6 August 2015

**Re: Letter of Strong objection to Staged Concept Proposal SSD6454- by SCECGS
Redlands 272 Military Road, Cremorne**

2 SITE PLAN - STAGE 1D PHASE 2
1 : 1000

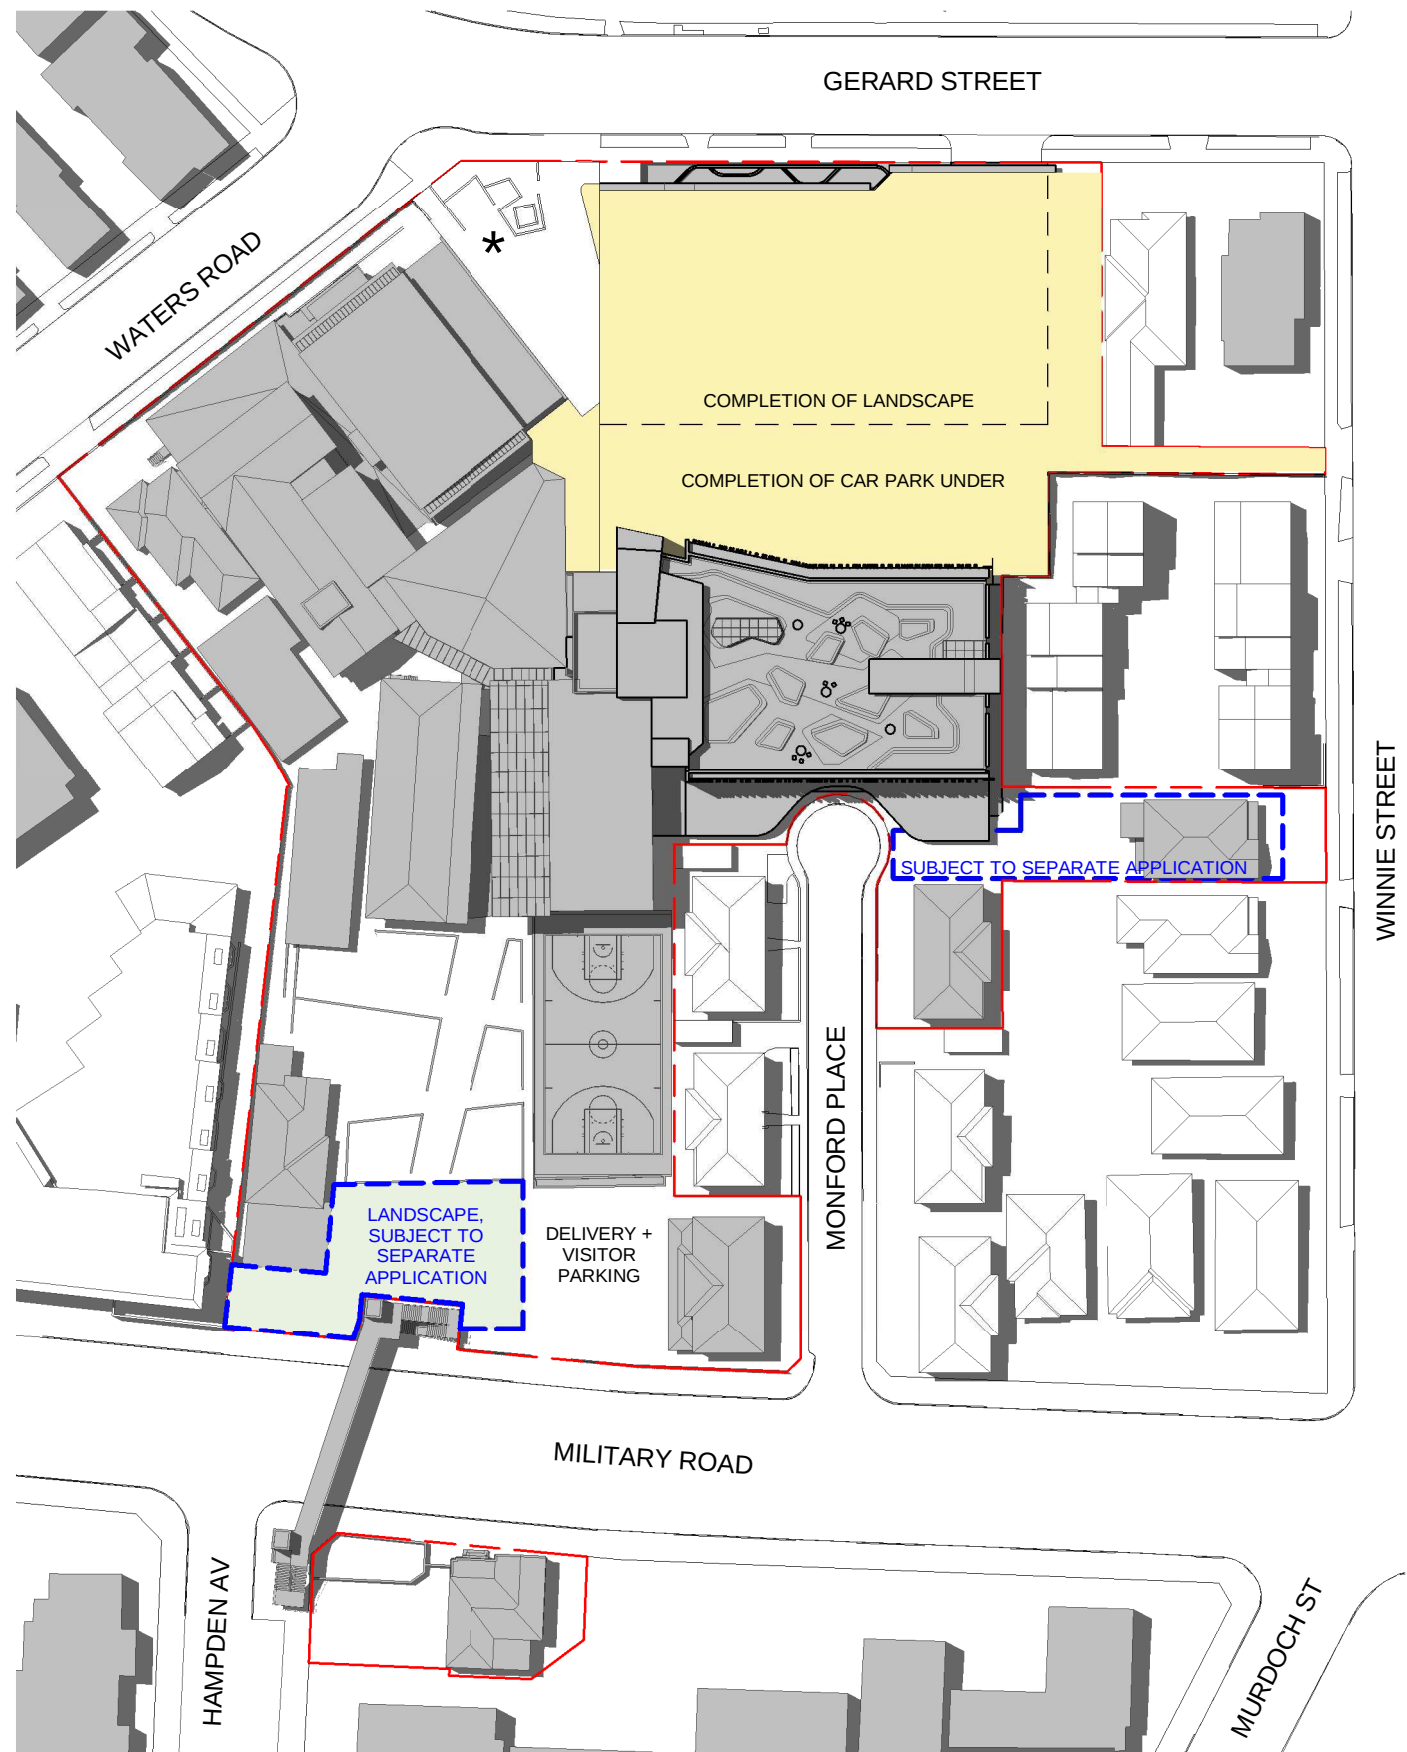
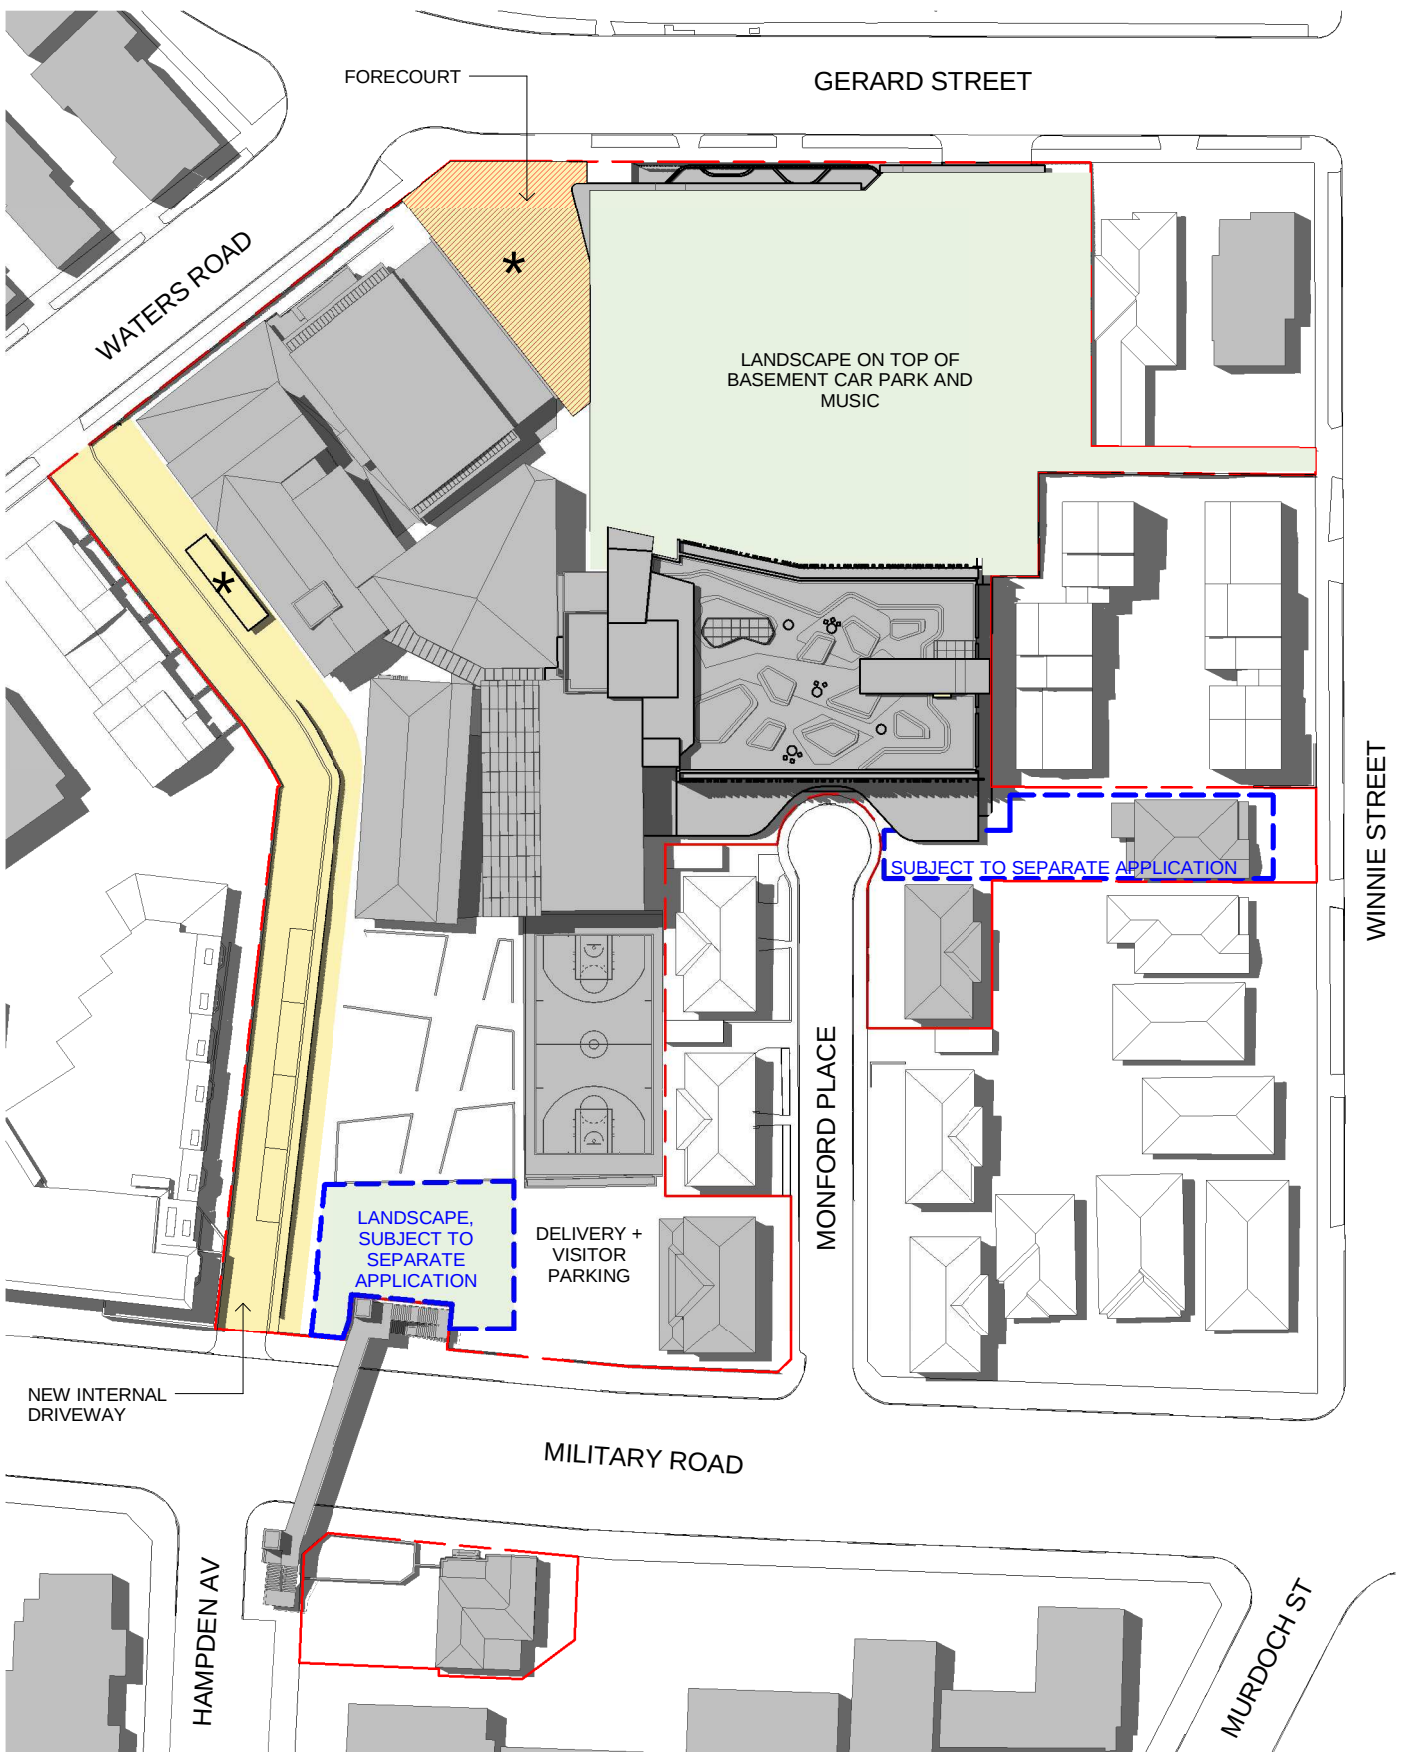
- **Access driveway along our boundary**

A driveway will build along the boundary of the land and property (having 6 units). During construction by the Proposal, this will be used by buses, vehicles and truck entering the site. During school operation, it will be used by school buses, visitors and garbage trucks early every weekday morning. On weekend, school buses and vehicles will use it in association with weekend activities.

Why does SCECGS need to build the driveway along our boundary? MY property is the residential house, not in commercial and industrial areas.

Therefore, the school must change the proposal of driveway to somewhere (e.g. the site of Military Road or Gerard Street) on the premises.

It is strange why the Proposal intends to install a garbage room along our boundary? My only private open space, lounge room and bedroom all face onto the proposed access handle, so other residents and I will be subjected to the noise and smell of tons of garbage and regular garbage truck movements. The locations of the access handle and garbage room are completely inappropriate, and push the unacceptable impacts of noise, smell, traffic and garbage trucks onto the neighbouring residences, rather than containing these impacts internally within the development.

The ill thought out placement of the internal road and garbage room will be both significant and unacceptable for me and other residents of 19 Waters Road.
